## DECISION DELEGATED TO HEAD OF PLANNING

**Application No:** H18-0752-25      **Applicant:** API Ltd

**Proposal:** Change of use from hotel Class C1 to residential Class C3 including the creating of 15 residential units - Approved under H18-0463-24.  
Modification of Condition 2 to allow amendments to previously approved plans

**Location:** Bridge Hotel 4 Bridge Road Sutton Bridge

|                                                                                       | Detailed Elevations                                    | As shown @ A1<br>Do not scale<br>from drawings |

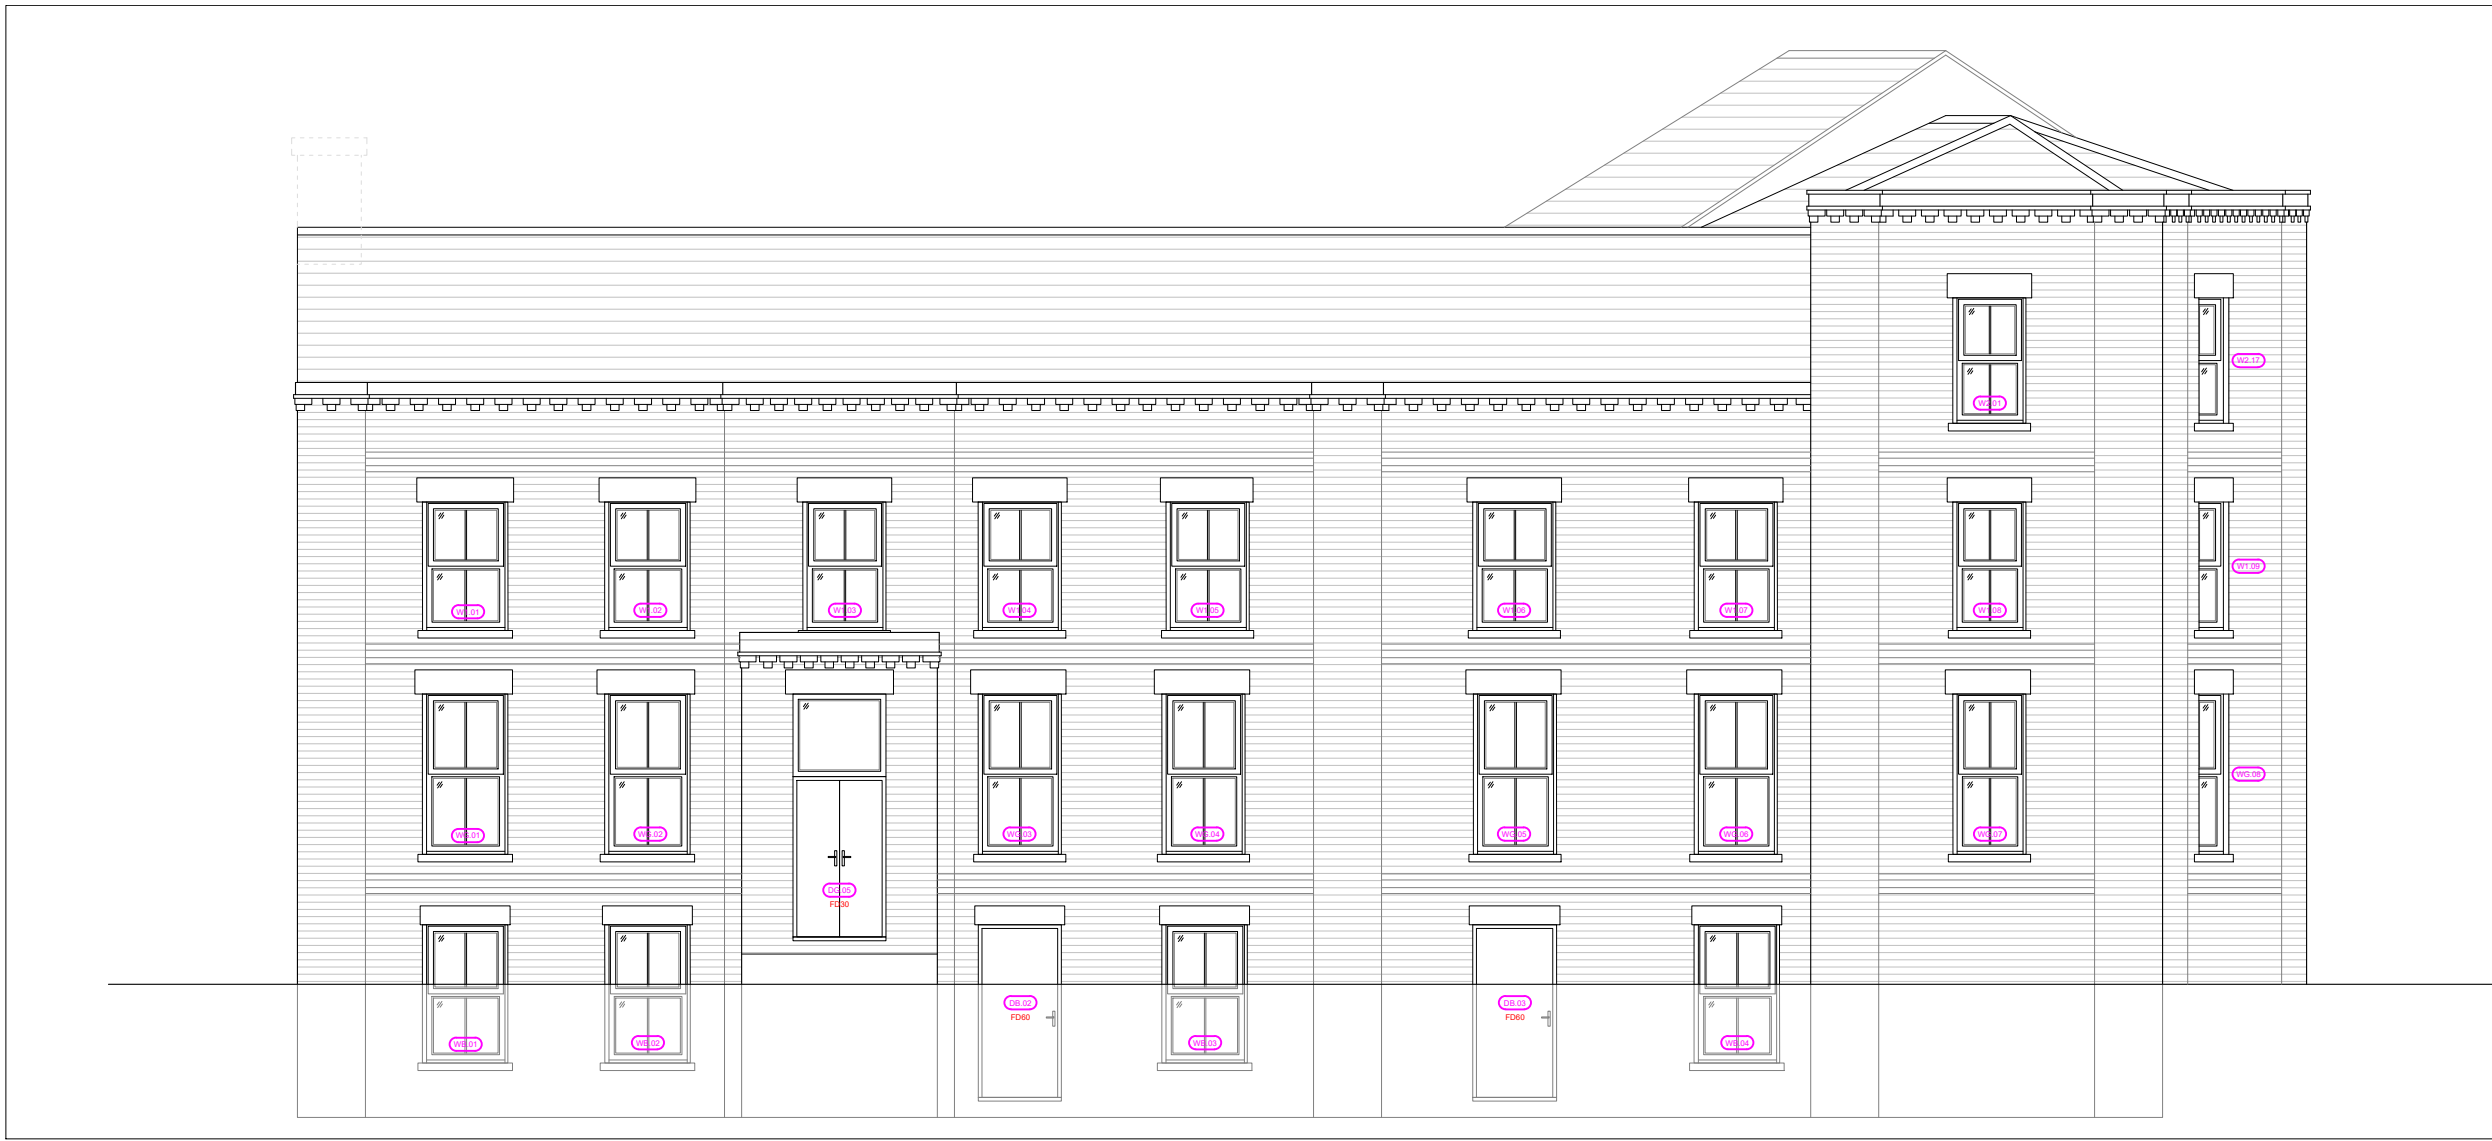
The proposed alterations are modest in scale, with the increase in roof height above Unit 15 being the most notable. This change is functional, enabling adequate headroom within the attic accommodation, while retaining the established gable form of the building. The proposed rooflights and minor window alterations (including adjustments to sill and lintel heights) are proportionate and visually consistent with the approved design.

The proposal would make limited impact, over the above proposal, in terms of its erect upon the neighbouring properties. The physical works, increase in roof height to the rear would have a limited impact by way of overshadowing/overbearing whilst all openings are in locations that would not result in unacceptable levels of overlooking.
